07 January 2019  
**Our Ref:** HA551502

### **Response to Section 51 advice following issue of decision to accept the application for Examination**

On 27 September 2018 the Secretary of State (the 'SoS') decided that the Highways England application for a Development Consent Order ('DCO') for the A30 Chiverton to Carland Cross scheme satisfied the acceptance tests under Section 55 of the Planning Act 2008.

**Appendix A:  
Applicant Response to Section 51 Advice and Section  
55 Checklist**

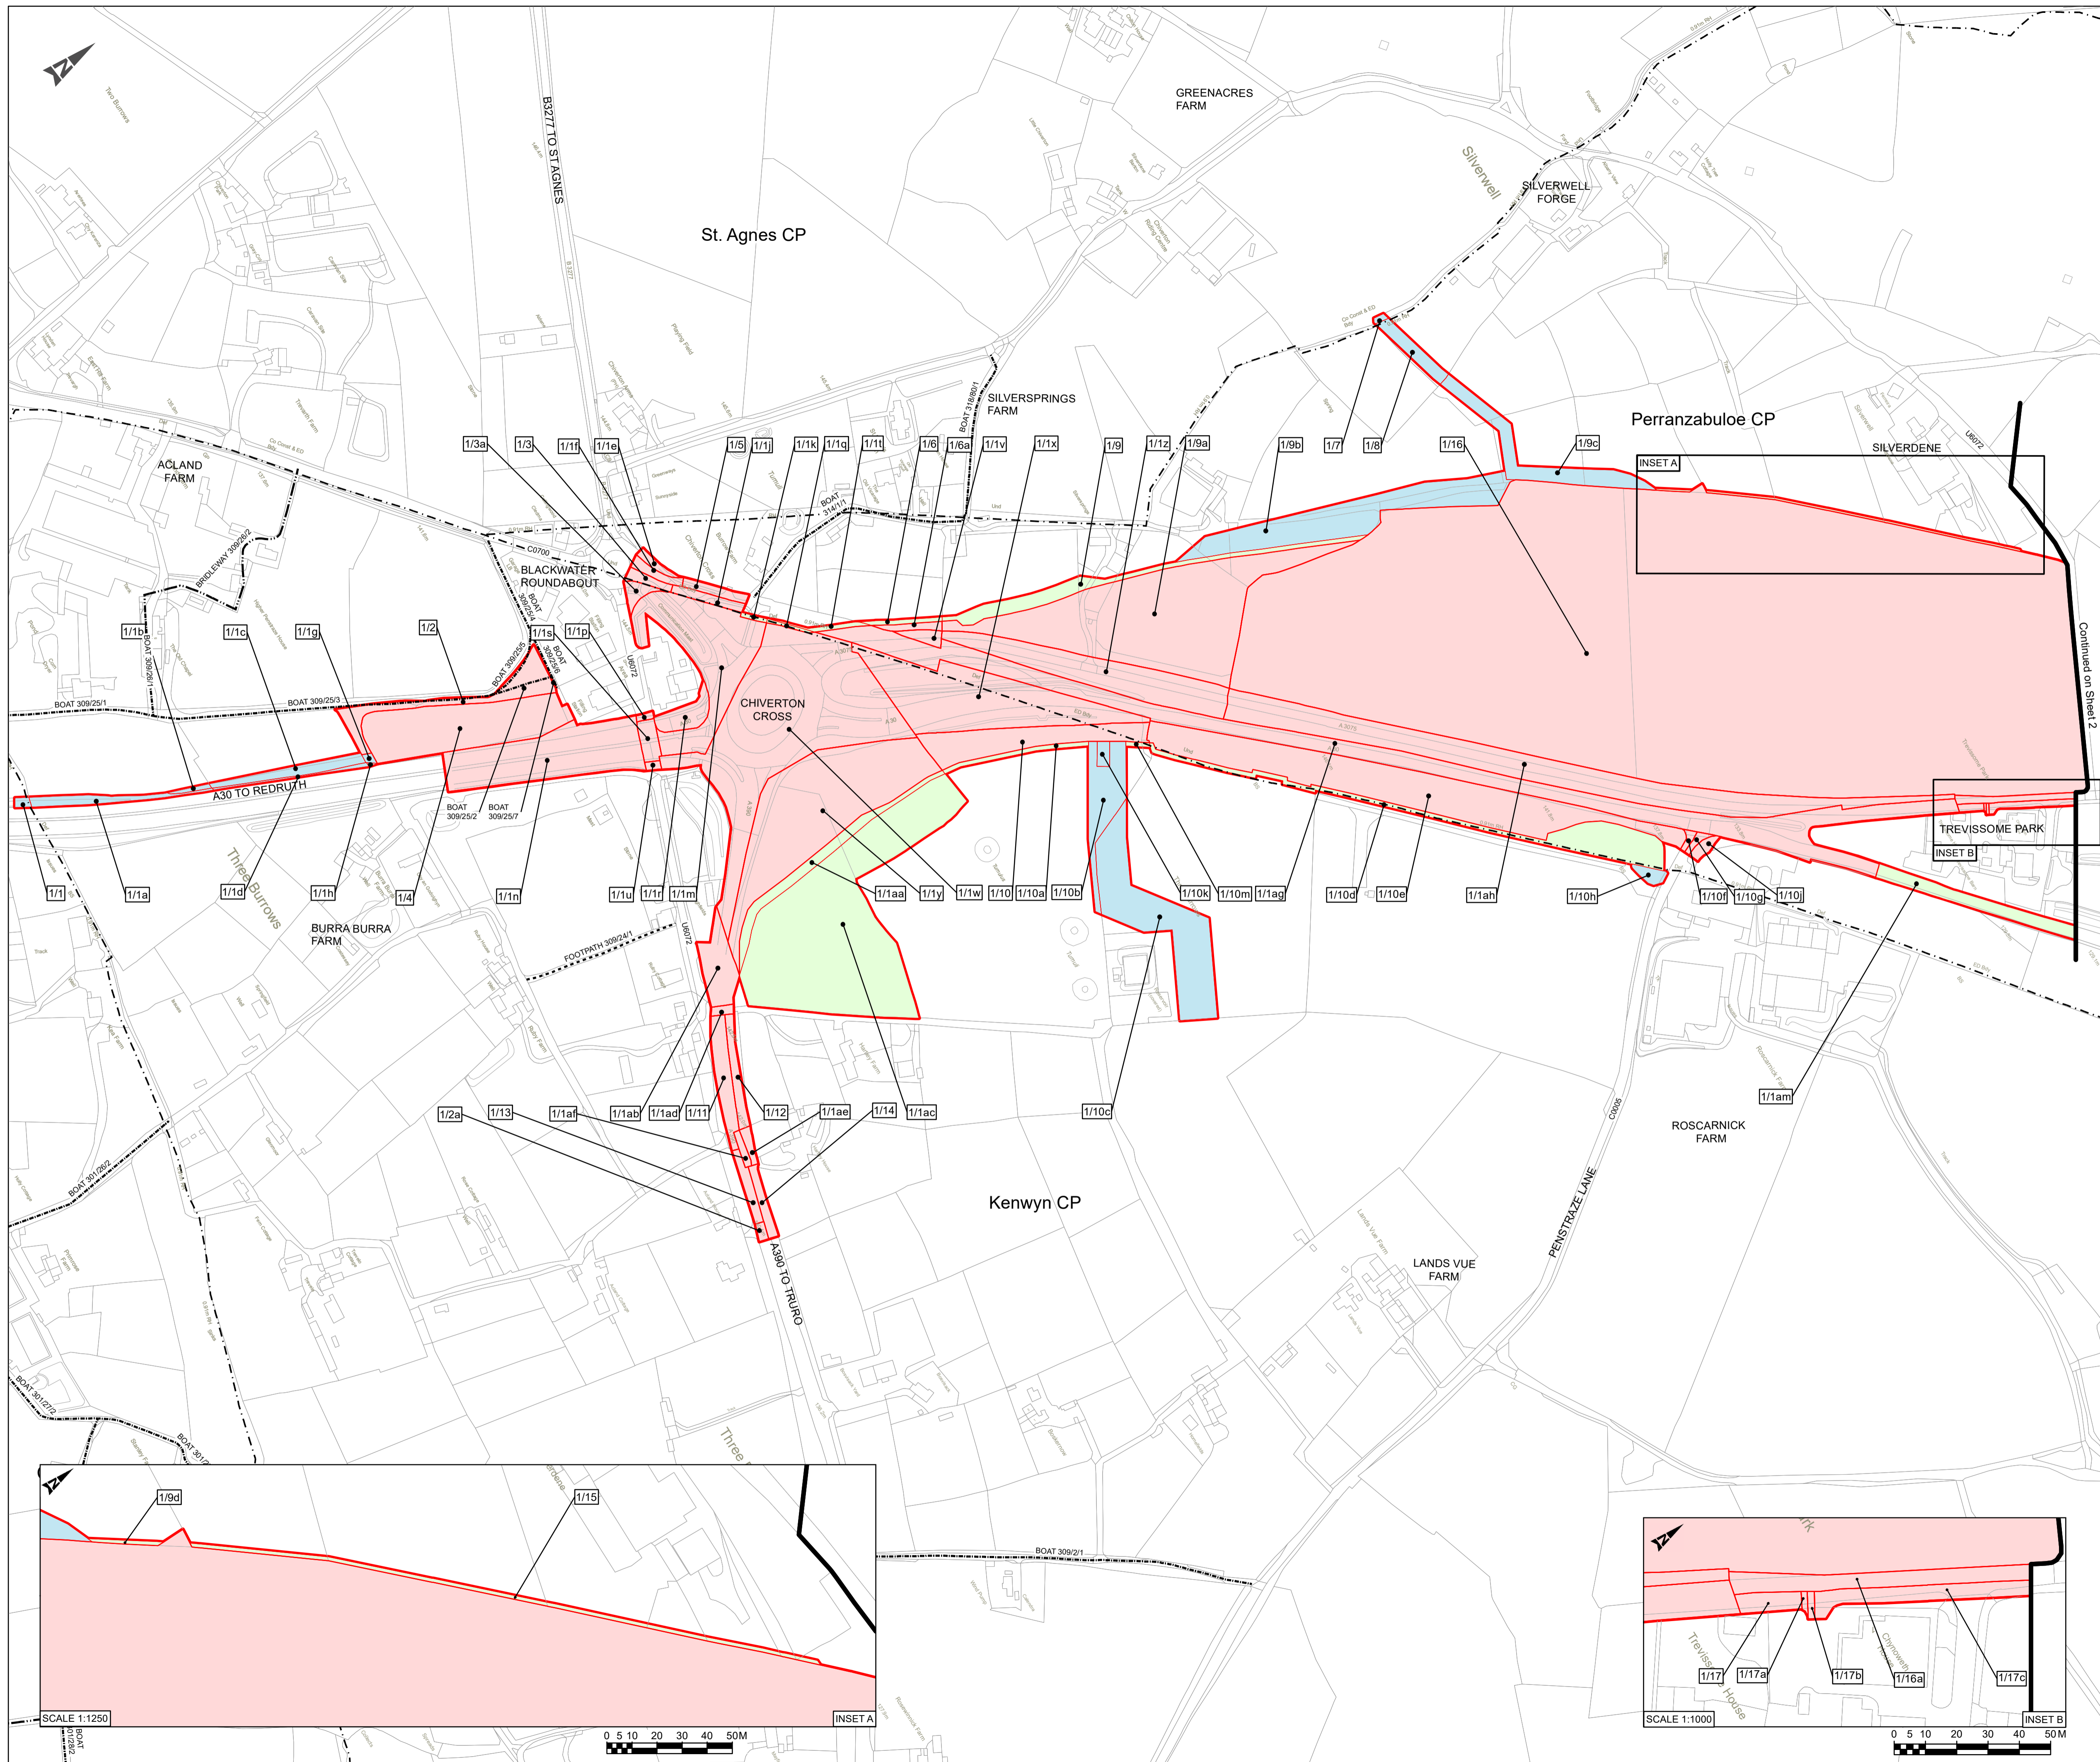
31	<p><b>Land Plans (Doc 2.2)</b> – queries regarding:</p> <ul style="list-style-type: none"> <li>• Sheet 1 – inset B, unidentified plot between plots 1/16 and 1/16a.</li> </ul>	<p>The unidentified plot between plots 1/16 and 1/16a has been assigned to adjacent plot 1/16a as shown on Sheet 1 of the Land Plans (Doc 2.2(A)).</p> <p>The area for plot 1/16a has been amended in the Book of Reference (Document Reference 4.3(A)) description and has increased from 501 square metres to 504 square metres.</p>
32	<ul style="list-style-type: none"> <li>• Sheet 3 – inset A, unclear small area of land in red between plots 3/1t and 3/1u.</li> </ul>	<p>The unidentified plot between plots 3/1t, 3/2e and 3/1u has been assigned to adjacent plot 3/2e as shown on Sheet 3 of the Land Plans.</p> <p>The area for plot 3/2e has been amended in the Book of Reference (Document Reference 4.3(A)) description and has increased from 25 square metres to 28 square metres.</p>

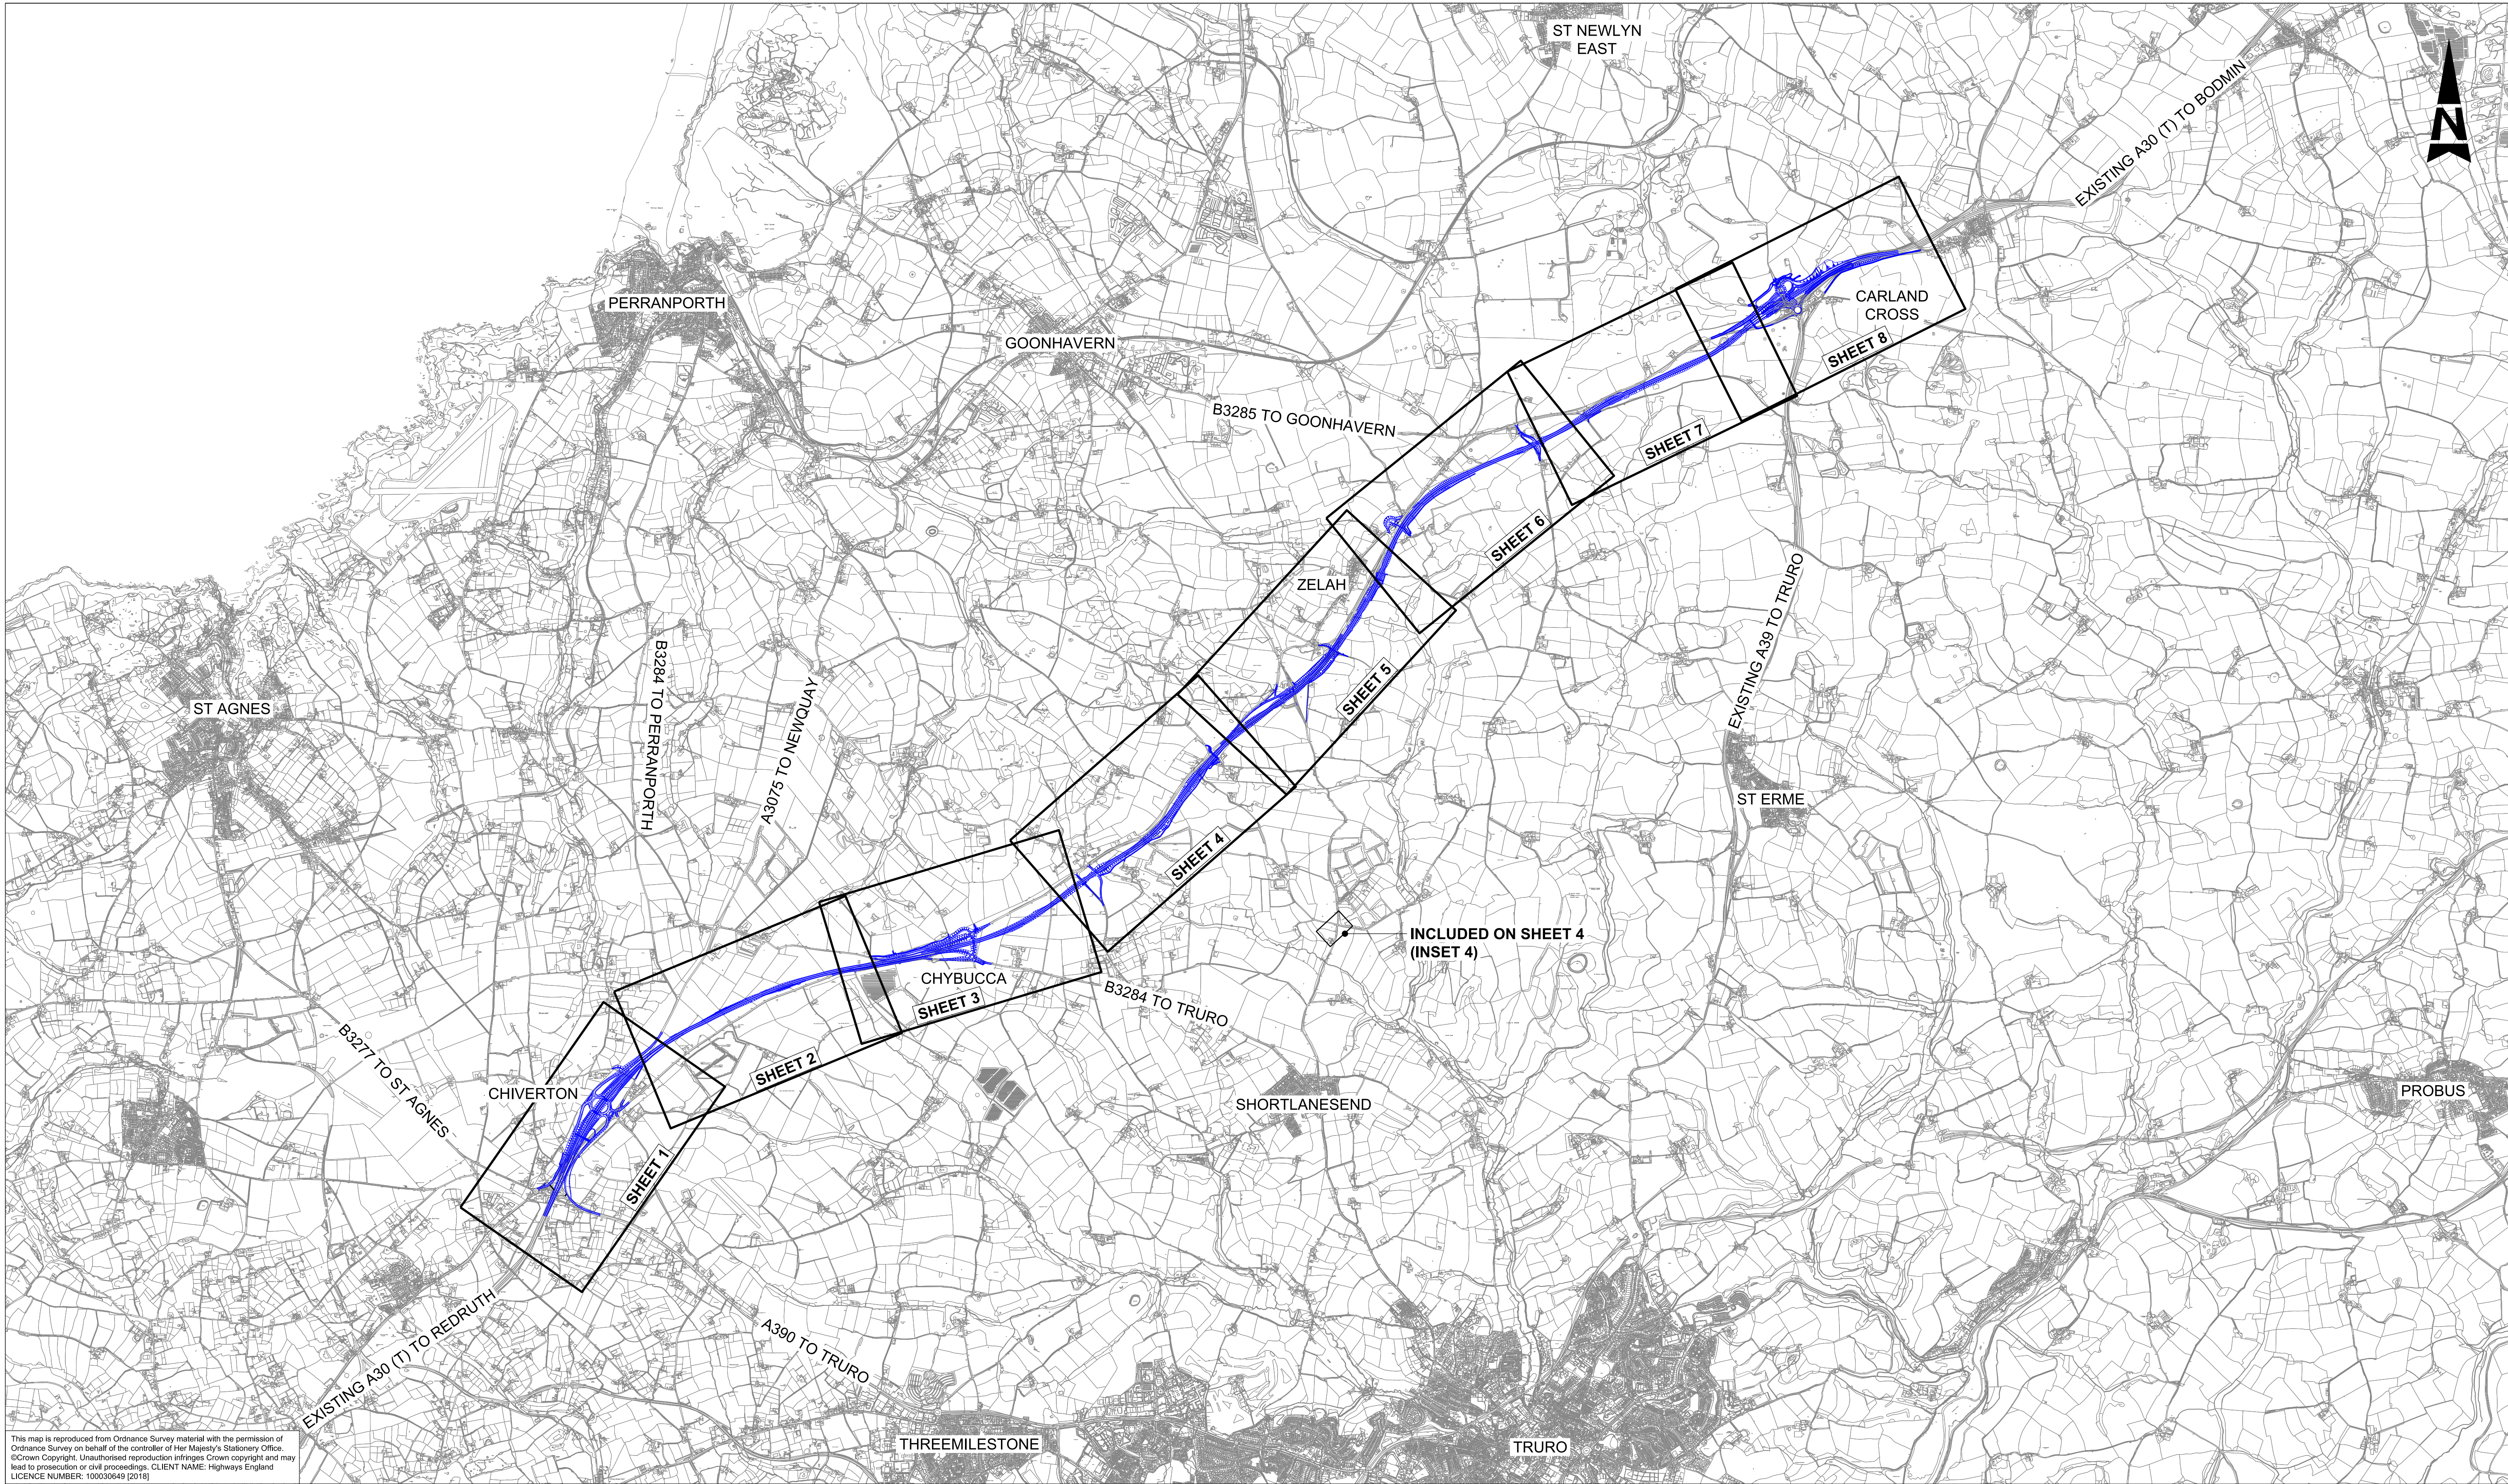
9.	<p>Adjustments to <b>Schedule 4</b> of the draft DCO:</p> <ul style="list-style-type: none"> <li>Schedule 4, Part 1 of the draft DCO (Doc 3.1) – where Reference Z12 (length of new restricted byway), the proposed restricted byway (Sheet 1 of Rights of Way and Access Plans Doc. 2.5) is shown on opposite sides of the carriageway, altering at the junction with the proposed restricted byway, Reference F, PR2 suggests it may be two separate restricted byways.</li> </ul>	<p>Schedule 4, Part 2 of the draft DCO – it is considered that Reference Z12 refers to one length of a single restricted byway. The byway is joined by a road crossing from one side of carriageway to the other.</p> <p>The same principle applies to Schedule 4, Part 2, Reference C (Sheet 1 of Rights of Way and Access Plans (Doc 2.5(A))).</p>
10	<ul style="list-style-type: none"> <li>Schedule 4, Part 2, Sheet 2 of the draft DCO (Doc 3.1), which refers to the existing A3075 from a point on existing Chiverton Cross Roundabout – it should reference sheets 1 and 2 of the</li> </ul>	<p>Schedule 4, Part 2, Sheet 2 of the draft DCO amended – text has been edited to read 'sheets 1 and 2 of the Rights of Way and Access Plans'. The length has been edited to read 1480m (from 810m).</p>

position on Sheet Numbers 1, 4, 5, 6 & 8 of the Works Plans.				
50	<p><b>Rights of Way and Access Plans (Doc 2.5)</b></p> <ul style="list-style-type: none"> <li>Sheet 1 shows a reference b, which relates to 'private means of access to be stopped up reference label' and 25, which relates to 'new private means of access reference label'. Reference to both within Schedule 4, Part 4 of the draft DCO (Doc 3.1) needs to be made.</li> </ul>	<p>Schedule 4, Part 4 of the draft DCO amended – the following text has been added to the table in Schedule 4, Part 4 of the draft DCO (Document Reference 3.1(B)).</p> <table border="1"> <tr> <td>Perranzabuloe and Kenwyn Civil Parishes</td> <td>Reference b Access to Three Burrows south east of the existing A30(T) and to the north east of the existing Chiverton Cross Roundabout</td> <td>At a point south east with the A30(T) for a length of 20 metres</td> <td>Reference 25 A new private access to Three Burrows to the north east of the existing Chiverton Cross Roundabout to the south of its existing access for a length of 12 metres</td> </tr> </table>	Perranzabuloe and Kenwyn Civil Parishes	Reference b Access to Three Burrows south east of the existing A30(T) and to the north east of the existing Chiverton Cross Roundabout	At a point south east with the A30(T) for a length of 20 metres	Reference 25 A new private access to Three Burrows to the north east of the existing Chiverton Cross Roundabout to the south of its existing access for a length of 12 metres
Perranzabuloe and Kenwyn Civil Parishes	Reference b Access to Three Burrows south east of the existing A30(T) and to the north east of the existing Chiverton Cross Roundabout	At a point south east with the A30(T) for a length of 20 metres	Reference 25 A new private access to Three Burrows to the north east of the existing Chiverton Cross Roundabout to the south of its existing access for a length of 12 metres			
<b>Regulation 5 (2) (l)</b>						
51	<p><b>The Habitats of Protected Species: Location of Badger Setts Plans (Doc 2.11)</b> are at a scale smaller than 1:2500; justification needs to be provided for this.</p>	<p>The plans have been submitted at the scale provided to improve legibility of the plans and to be able to show the features in relation to each other.</p>				
<b>Regulation 5 (2) (m)</b>

Rights of Way and Access Plans, as opposed to 2 and 3 of the Rights of Way and Access Plans (Doc 2.5)	Sheet 1 of the Rights of Way and Access Plans has been amended to show the stopping up from the existing Chiverton Roundabout.
11	<ul style="list-style-type: none"> <li>Schedule 4 – where reference is made to the alignment ‘on’ the realigned carriageway, in relation to several proposed rights of way – this is an incorrect description of a proposed separate public highway</li> </ul>	Descriptions in Schedule 4 of the draft DCO have been amended to say ‘adjacent to’ where a proposed right of way runs alongside a carriageway.
<b>Regulation 5 (2) (d) Book of Reference (Volume 4, Document Reference 4.3)</b>		
12	<b>Book of Reference (Doc 4.3)</b> <ul style="list-style-type: none"> <li>Plot 1/9 - west of Silversprings Farm, should be east according to Sheet 1 of the Land Plans (Doc 2.2);</li> </ul>	Book of Reference (Document Reference 4.3(A)) description for Plot 1/9 amended to read east of Silversprings Farm to match the location shown on Sheet 1 of the Land Plans.
